Recommendation Report for Planning Permission for Works or Extension to a Dwelling

REF NO: BR/232/24/HH

LOCATION: 11 Chichester Road
Bognor Regis
PO21 2XG

PROPOSAL: Proposed loft conversion. Adjustments to the fenestration.

11 CHICHESTER ROAD
BOGNOR REGIS
PO21 2XG
PROPOSED PLANS AND ELEVATIONS
(SC. 1:100 @ A1)
DRAWING NO: PL 304 A
NOV 2024

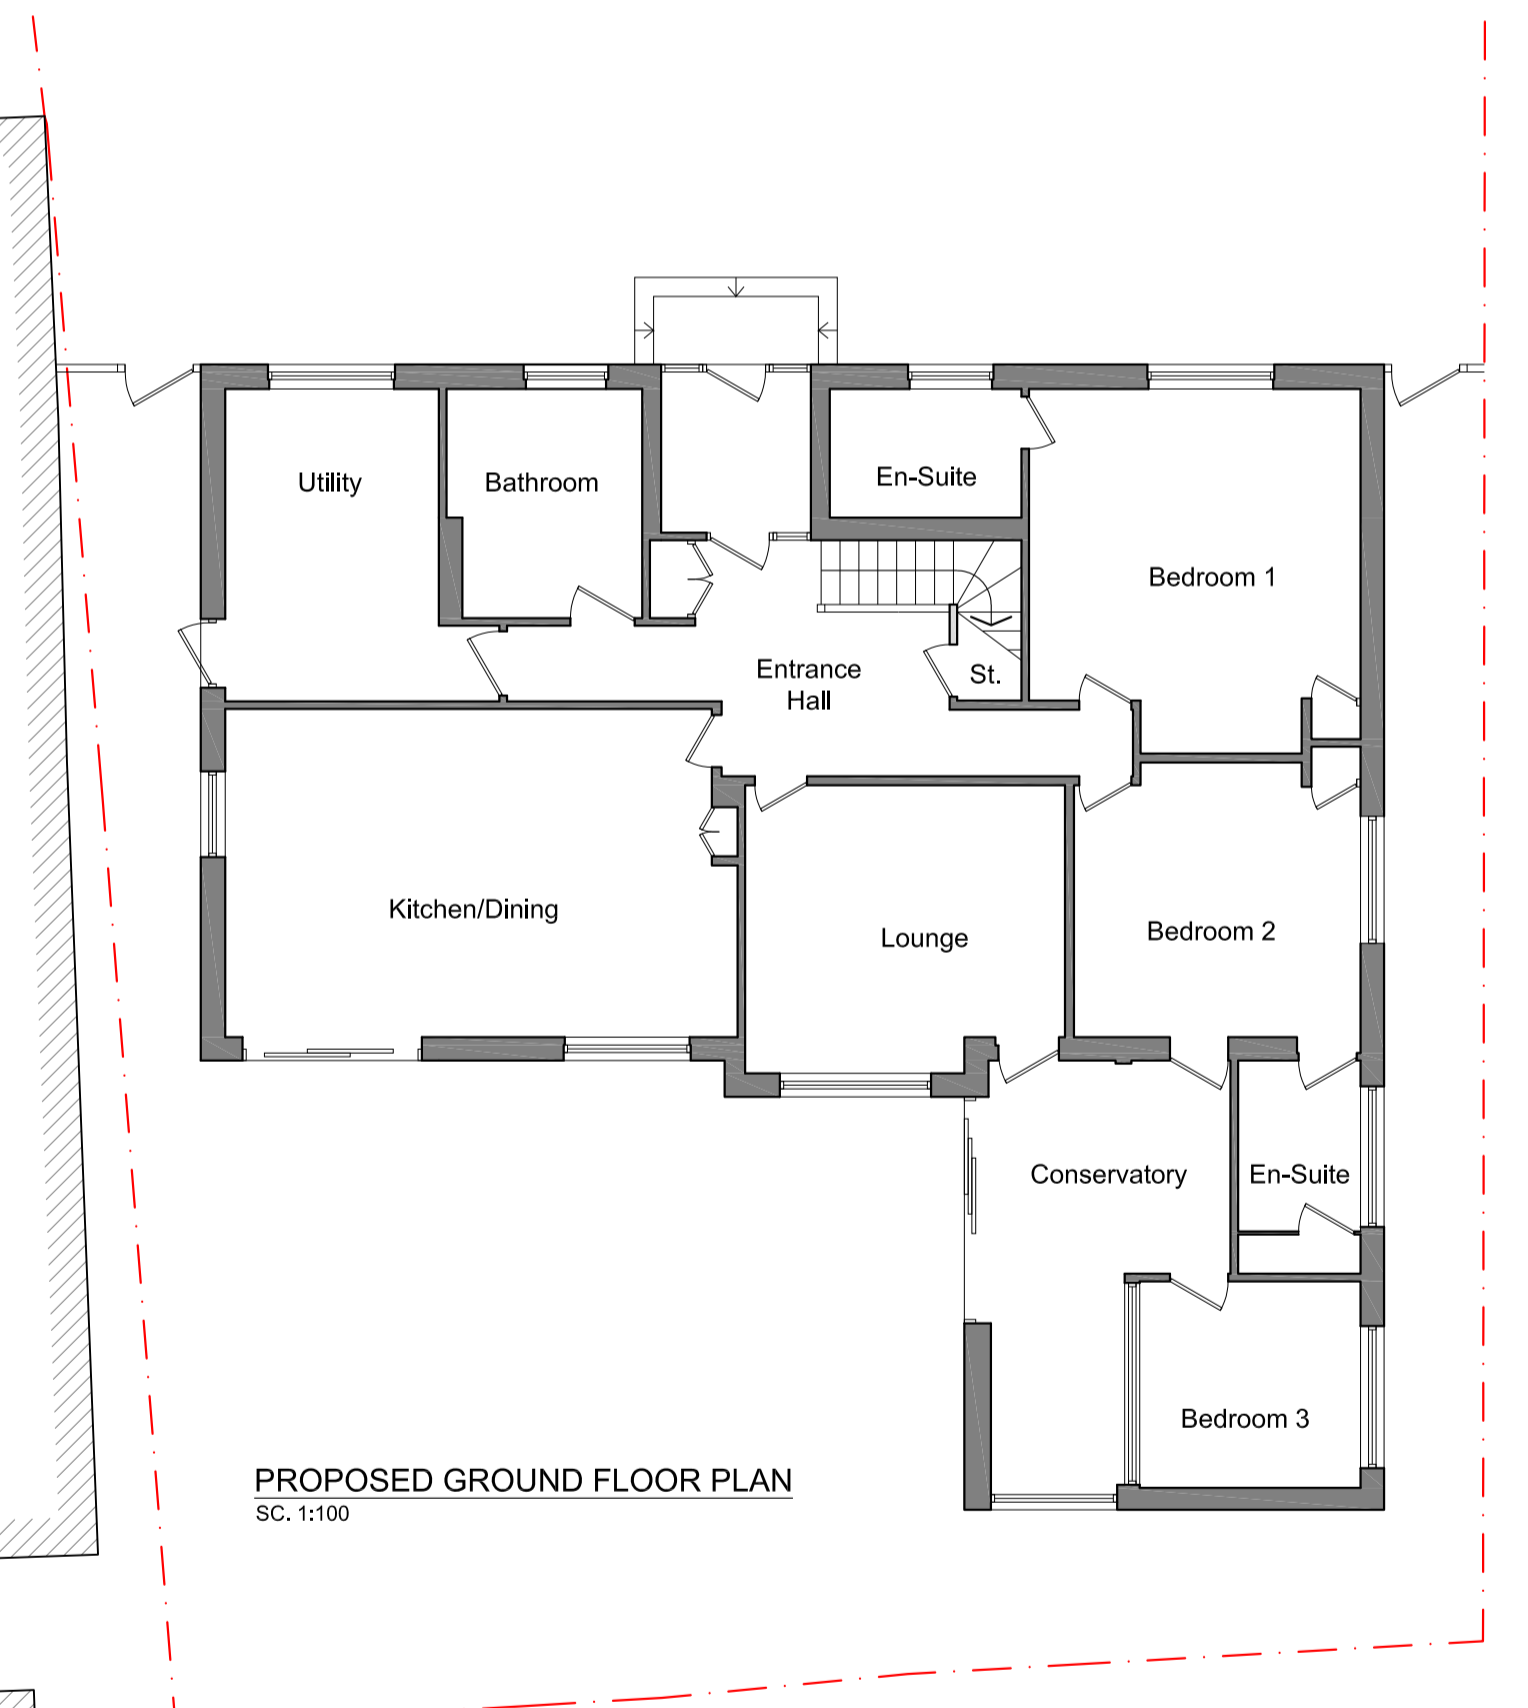
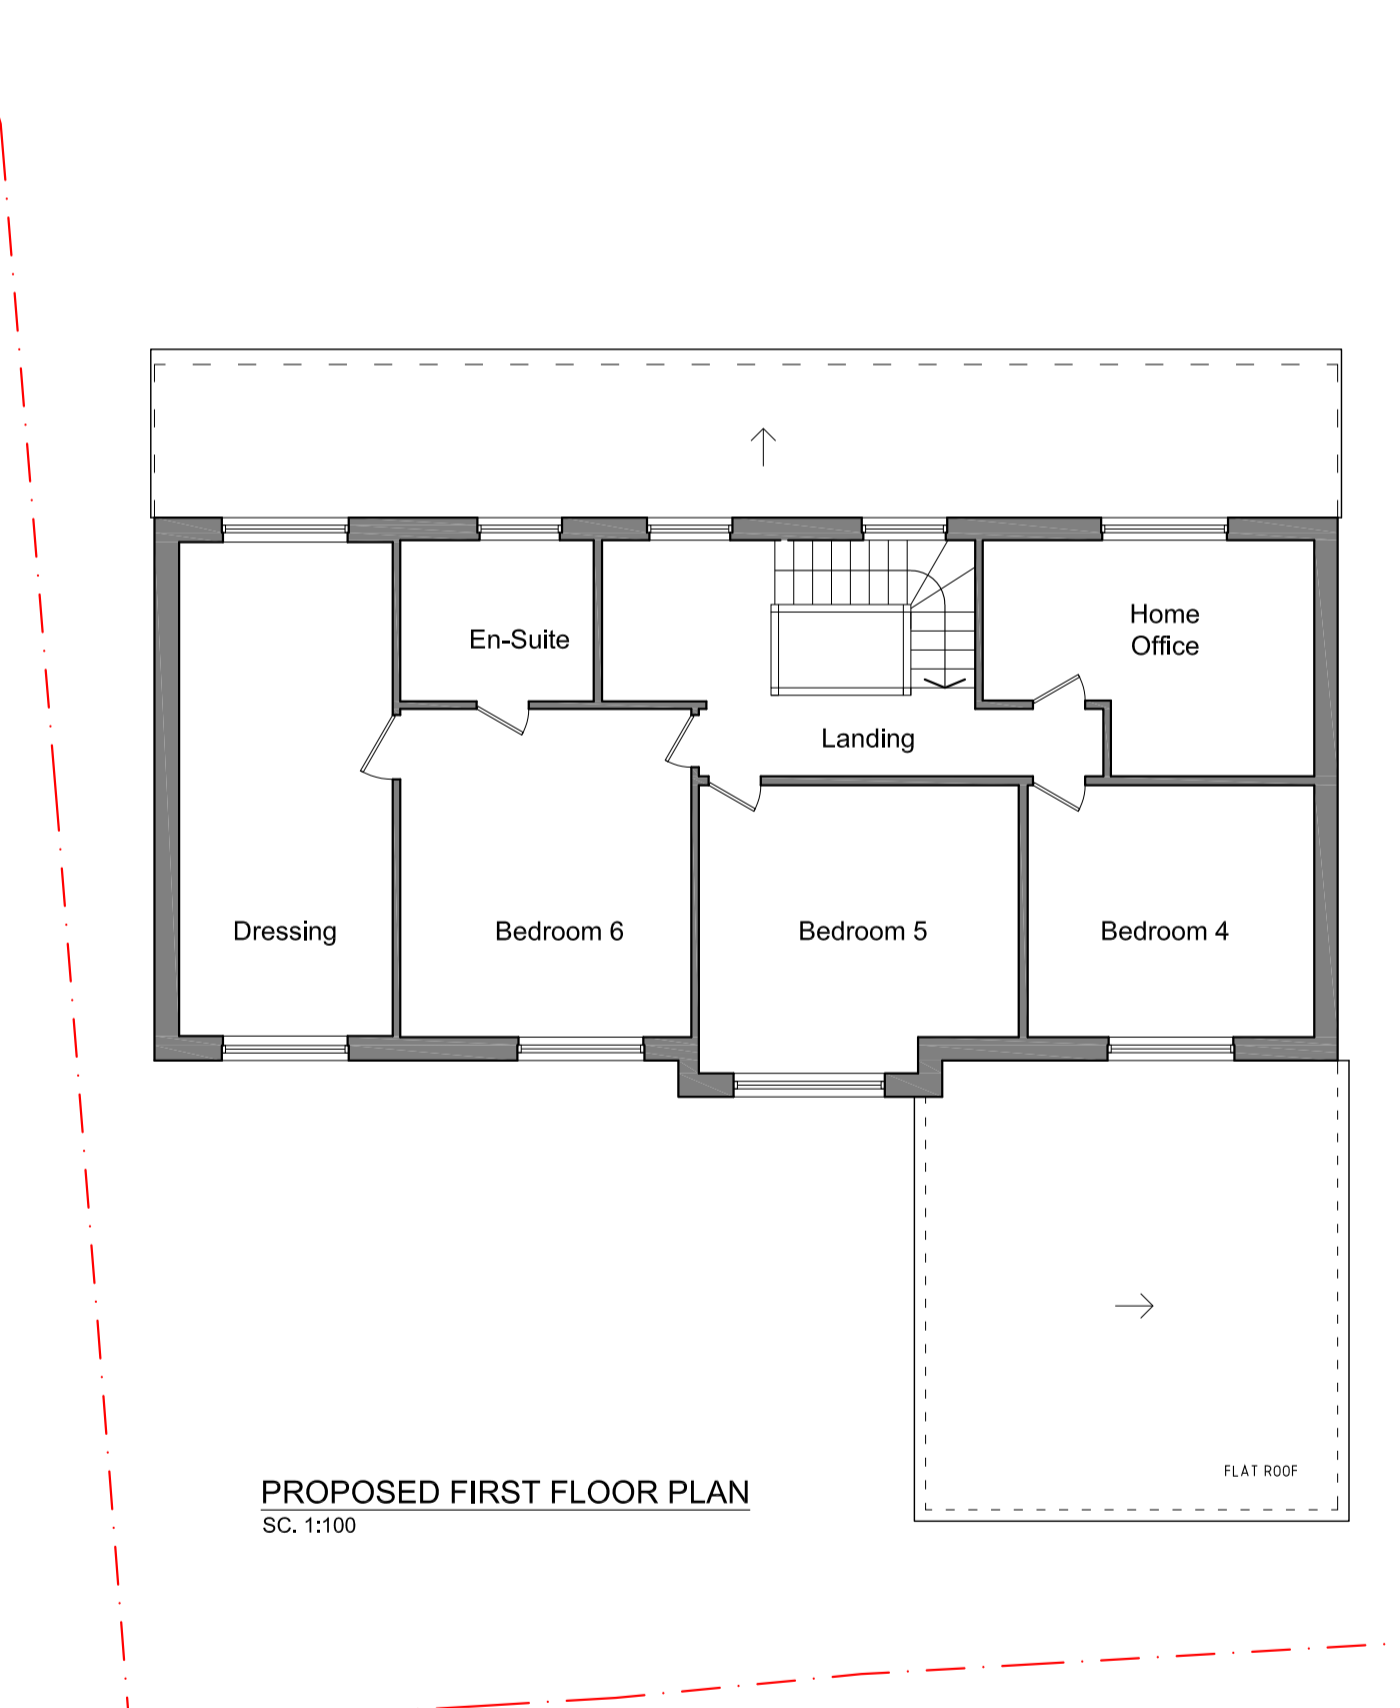
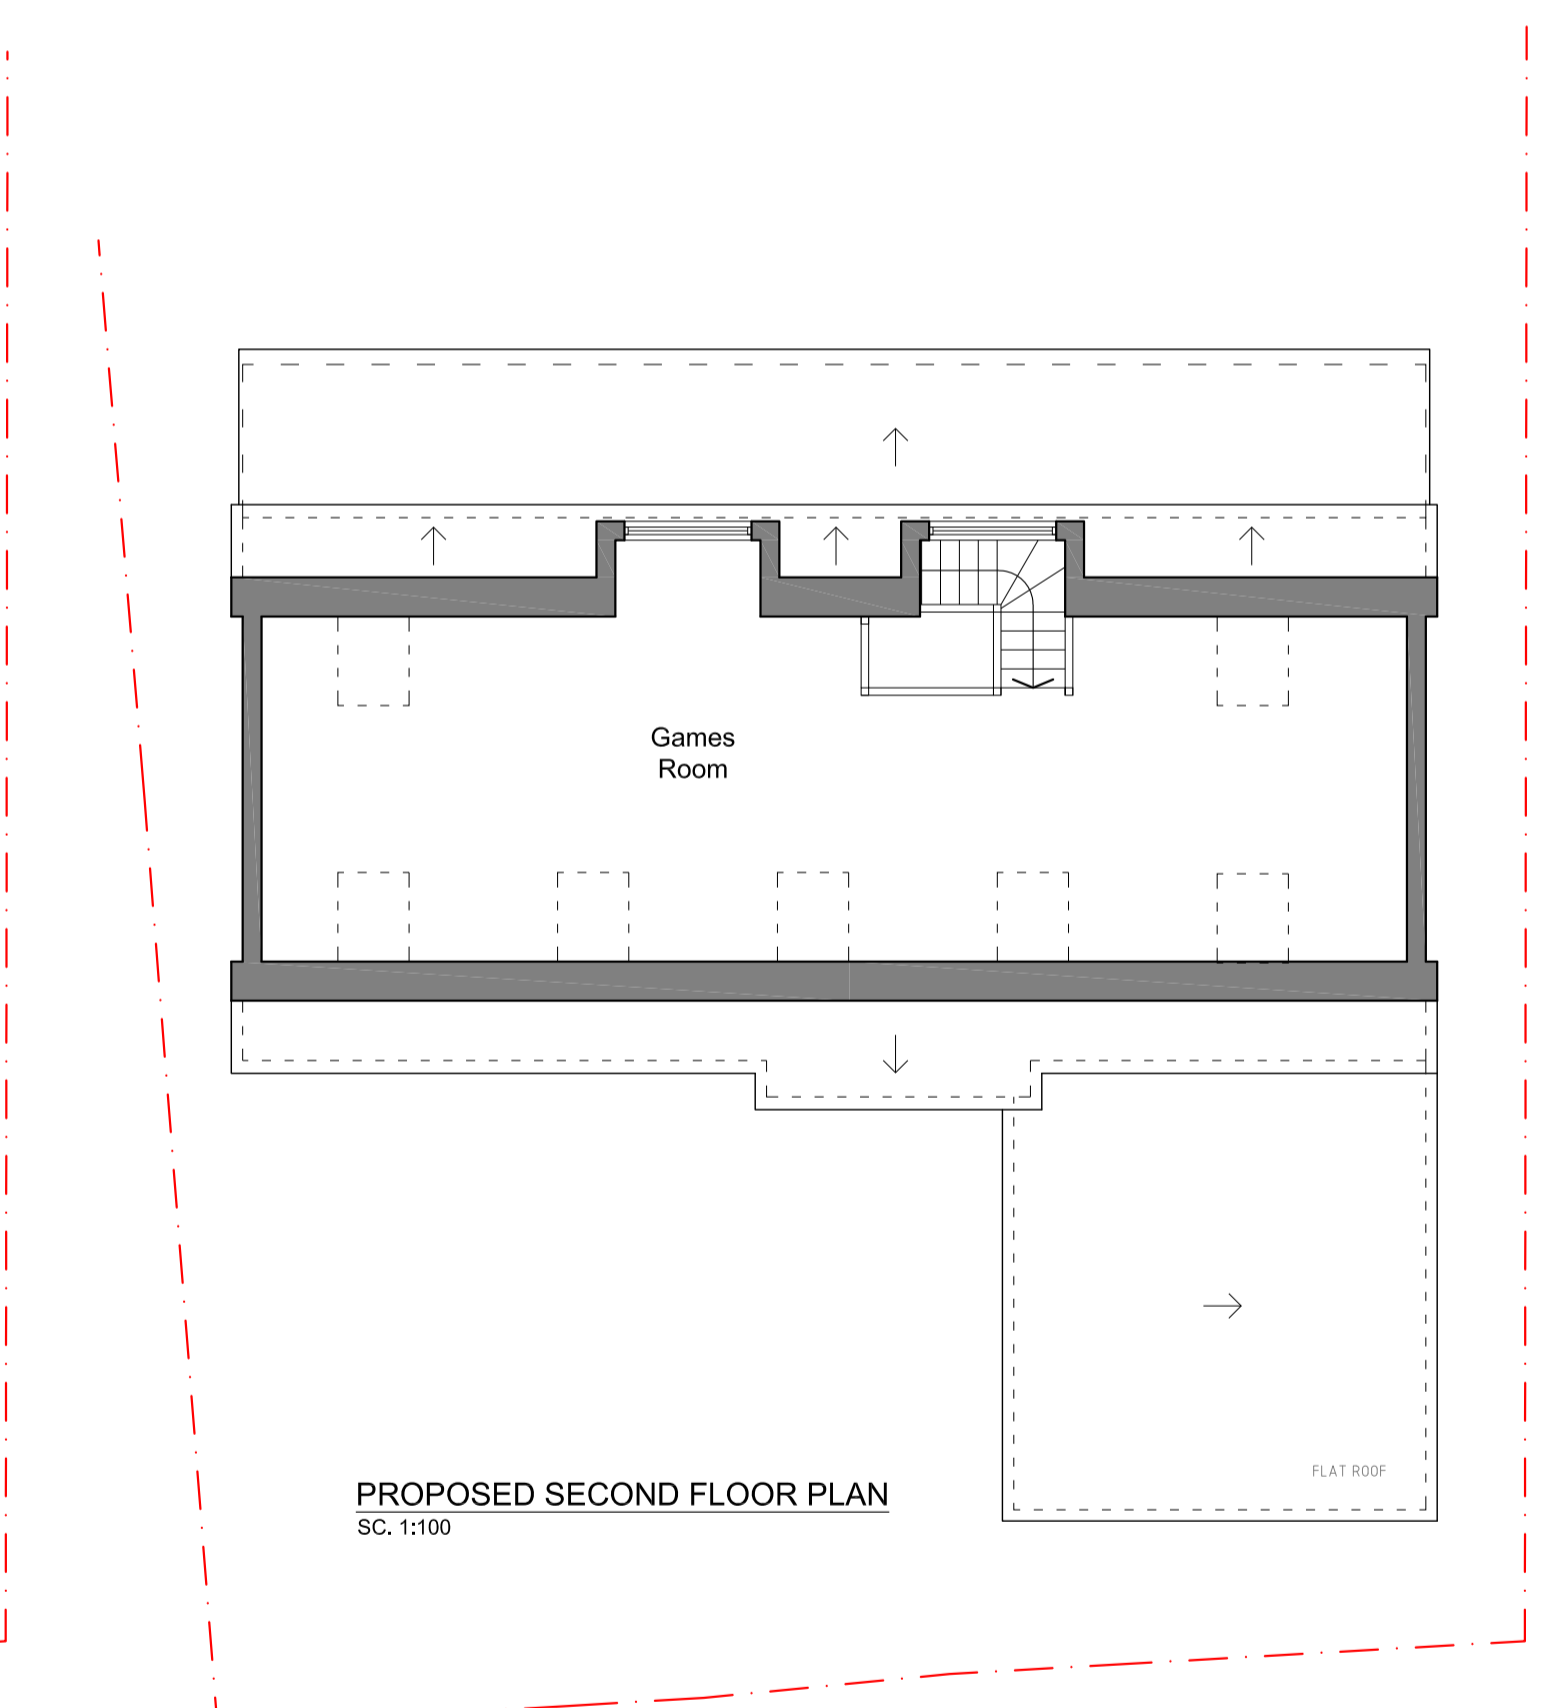
The amended design to install 2 flat roofed dormers to the front elevation is an improvement to the previous application; with the dormers appearing more sympathetic in scale to the main roof. They are a less dominant feature of the roof form than previously, and would appear more reflective of other smaller flat roofed dormers in the vicinity. They measure a maximum height of 8.5m from the ground floor, with a width of approximately 2.5m and projection from the roof slope by 3.2m. Whilst flat roofed dormers are generally less desirable from a design perspective over hipped or gable roof dormers which have more visual appeal, in this case the proposal is not of significant enough harm to visual amenity to warrant a reason for refusal. The dormers are proportional to the roof form, not overly dominant, and integrate with the visual appearance and character of the dwelling itself. Given the varied appearance and character of other properties in the surrounding property, the dormers would not appear unduly out of keeping with the rest of the street scene. As such, the dormers to the front elevation are acceptable.

It is proposed for external walls of the dormers to be clad with weatherboarding (Hardie Plank Cedar) in the colour Grey Slate. There are few examples of weatherboard cladding in the immediate vicinity; however there is use of this material in the wider locality. Given the minor amount of weatherboarding that would be used, its incorporation is acceptable.

In regard to the loft conversion itself, and introduction of rooflights to the front and rear elevation, these works are acceptable given their minor impact on the visual appearance and character of the building. They would have no adverse harm to the visual amenity of the property, or the surrounding area.

The proposal would see the introduction of 2 dormers to the front, at a height of 8.5m; and 7 rooflights at a height of approximately 7.6m. Whilst these would be substantial additions to the roof form, especially in regard to the dormers, their location is such that the impact on residential amenity does not result in demonstrable harm. The dormers to the front would not unduly overbear or overshadow either neighbouring property, and would provide an outlook that overlooks the street scene and roundabout. The dormers would not provide any overlooking opportunities which would result in adverse harm to residential privacy or amenity.

The rooflights to the rear would not be overbearing or overshadowing, by virtue of their location flush to the roof plane; however they would increase the opportunity for overlooking, being on the rear elevation. This elevation abuts the rear gardens of properties in Annandale Avenue and Victoria Drive, providing additional views of the rear elevations. Whilst the location of the rooflights would give some visibility of the rear gardens, due to the nature of the rooflights being sloped, this would be limited. Any views harmful to amenity would only be possible with intention, and such would not be incidental overlooking easily accessible to the viewer.

- 3 The materials and finishes of the external walls and roofs of the building hereby permitted shall match in colour and texture those of the existing building. This is with the exception of the external walls of the dormers, which shall be Hardie Plank Cedar Cladding in Grey Slate.
